ASSESSMENT REPORT

SENIORS LIVING DEVELOPMENT 34-36 MEMORIAL AVENUE, KELLYVILLE MP 09_0180 (MOD 7)

Apartment Design Guide (ADG)
Part 3F: Visual Privacy

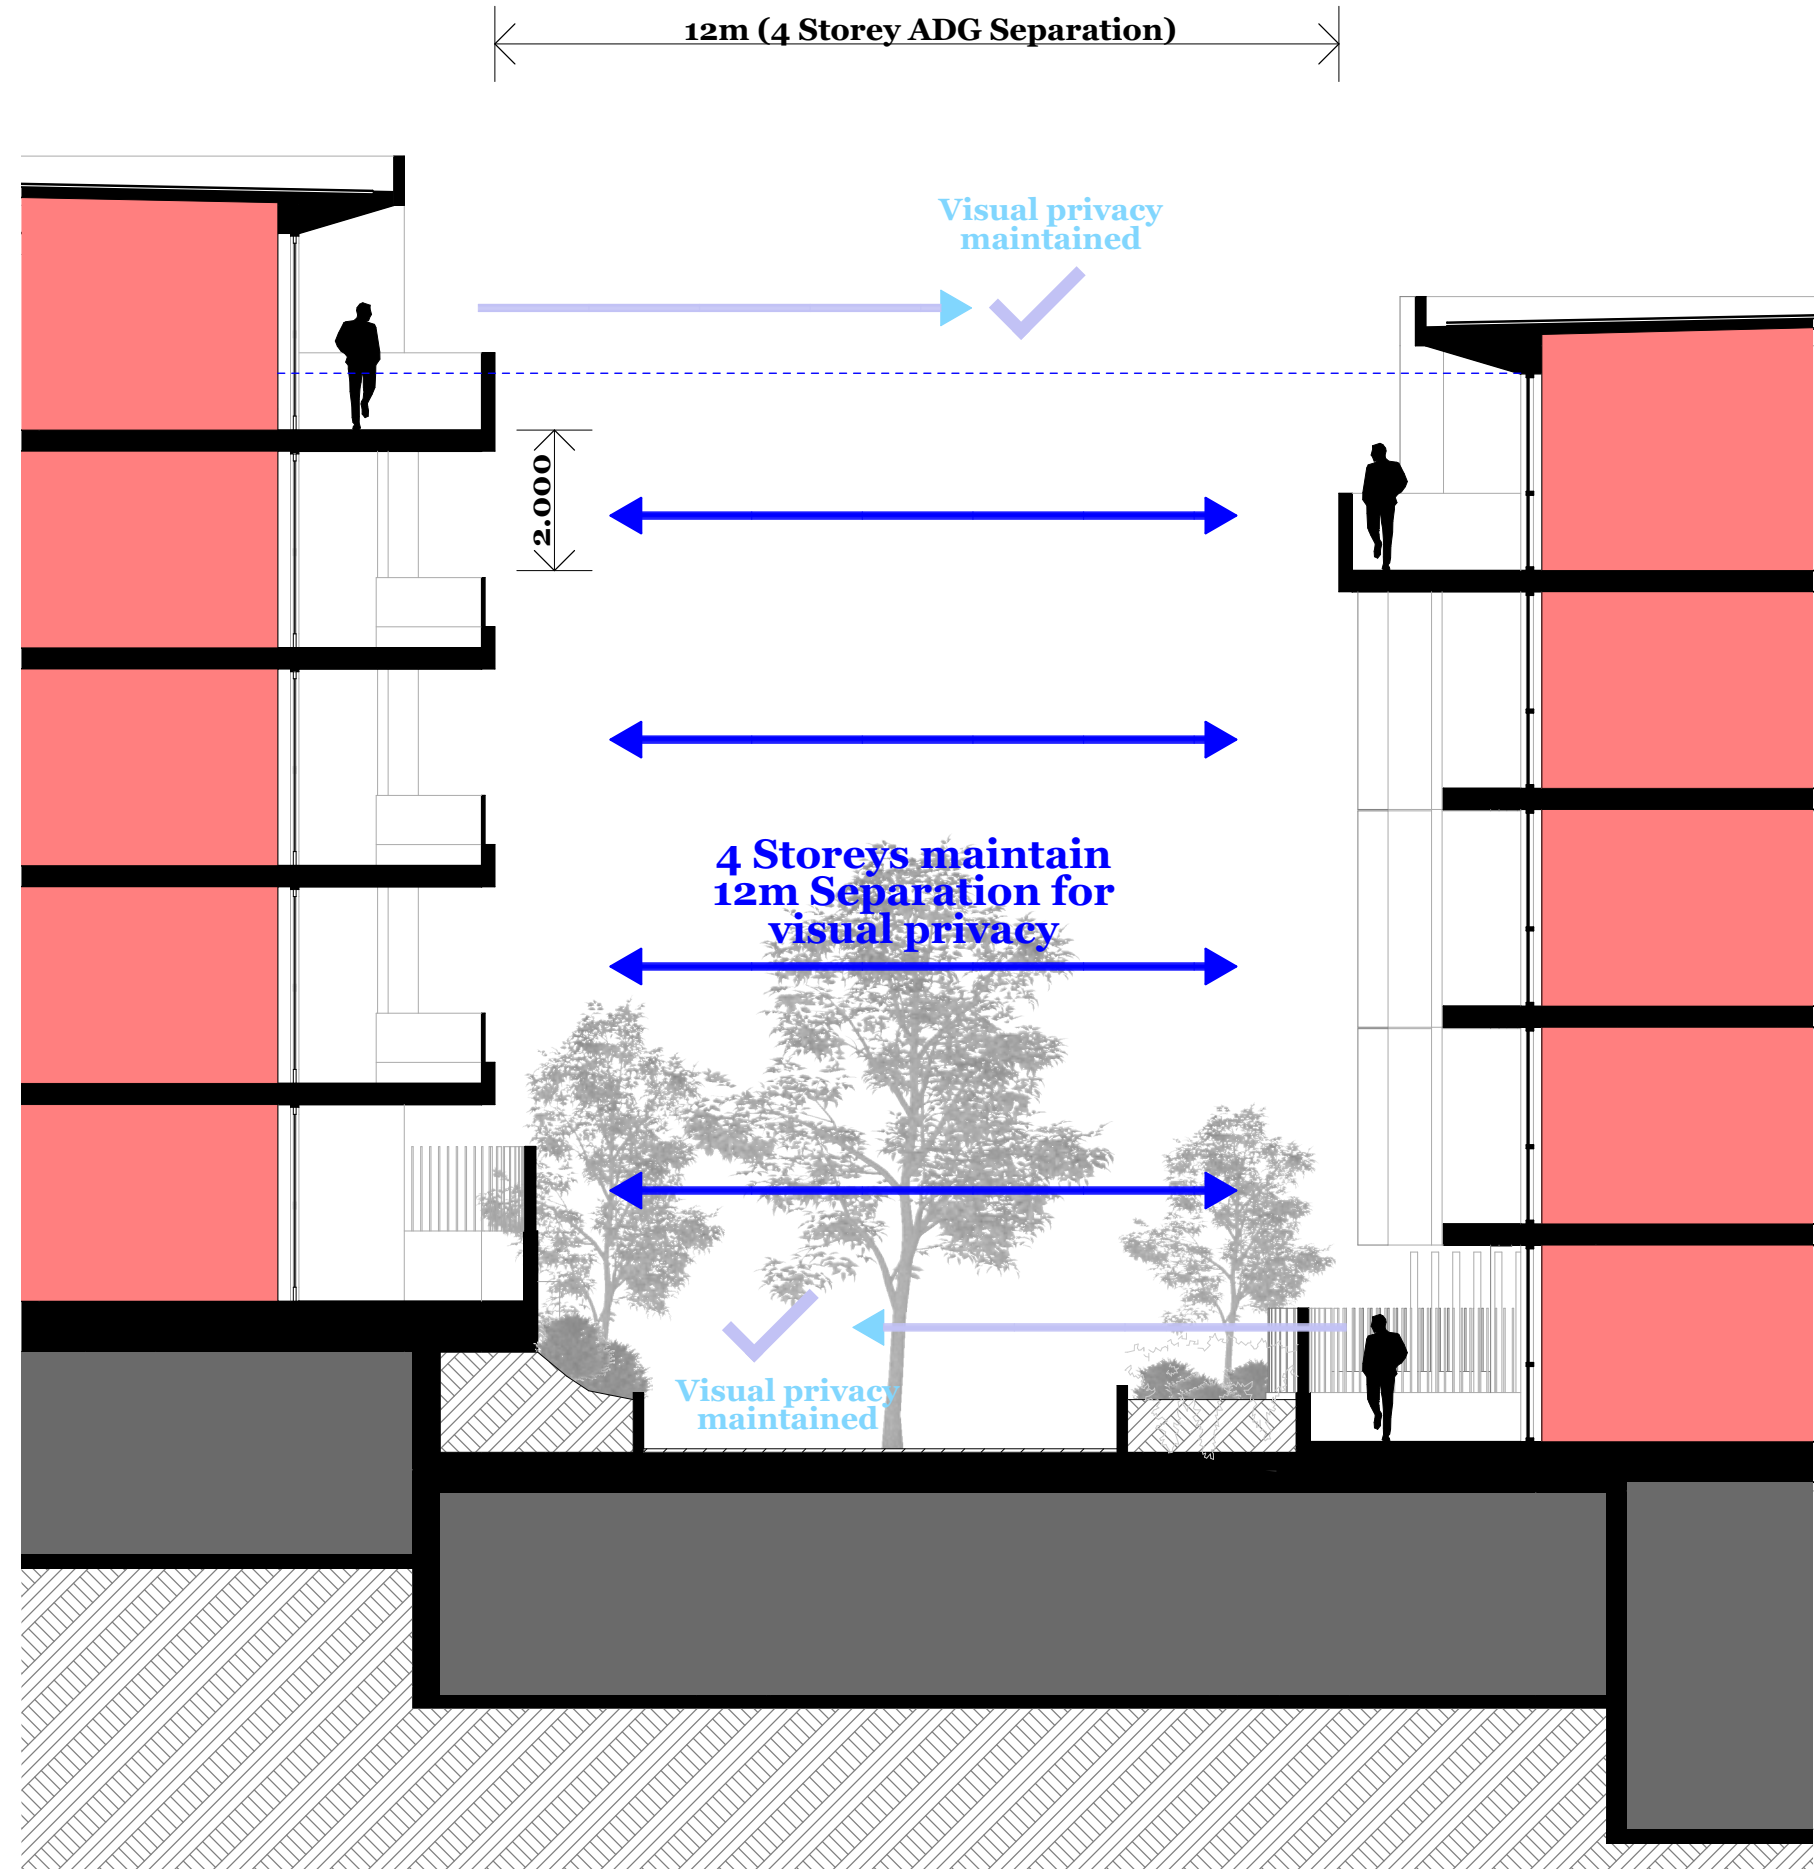
- building separation (between clusters 2, 3 and 4 and also with exiting clusters 1 and 5) does not comply with the Apartment Design Guide (ADG) and should be increased to ensure suitable amenity

- the proposed modification does not meet the guidelines of the ADG at the fifth-floor level, in terms of separation between proposed Clusters 2, 3 and 4, as well as separation with existing adjoining Clusters 1 and 5
- consideration should be given to overshadowing of open space areas and adjoining buildings due to building height exceeding the 16m control
- consideration should be given to the acoustic impacts from noise emanating from the waste serves area and noise insulation from Memorial Avenue.

To minimise privacy impacts between apartments, the ADG recommends a minimum building separation of 12 metres for buildings up to 4 storeys in height and 18 metres for buildings 5 storeys and above. The proposed development complies with the separation requirements up to the fourth storey. However, the proposal does not comply with the 18 metre building separation requirement for the fifth storey, with building separation distances of:

- 12 m to 19.9 m between Clusters 2, 3 and 4

- 15.7 m - 17.0 m between Clusters 1 and 2
- 17.6 m - 17.7 m between Clusters 4 and 5.

- most units at the fifth storey exceed or come close to complying with the ADG requirements for building separation
- due to the site topography, there is a height difference between each building resulting in the upper west facing units being elevated so that they are not overlooked
- the difference in height between units (due to the site topography) helps minimise direct overlooking
- balconies on the fifth level have solid balustrades
- all apartments would have internal window coverings.

The Department considers the proposal would result in improved building separation compared to the current approval. As approved, Clusters 2, 3, and 4 included a floor plan arrangement where units were separated by small internal courtyards, approximately 12 metres in width (**Figure 4**). The proposed floorplate removes the internal courtyard and consolidates the building footprint, resulting in improved separation and amenity outcomes for the units.

The revised building footprints also allow for improved separation between each of the clusters, including significant improvements for separation from Cluster 5 (from 8 -12 m separation as approved to 17.6 m as proposed). Given the generous building separation now proposed between Clusters 4 and 5, an existing condition requiring privacy measures to be provided
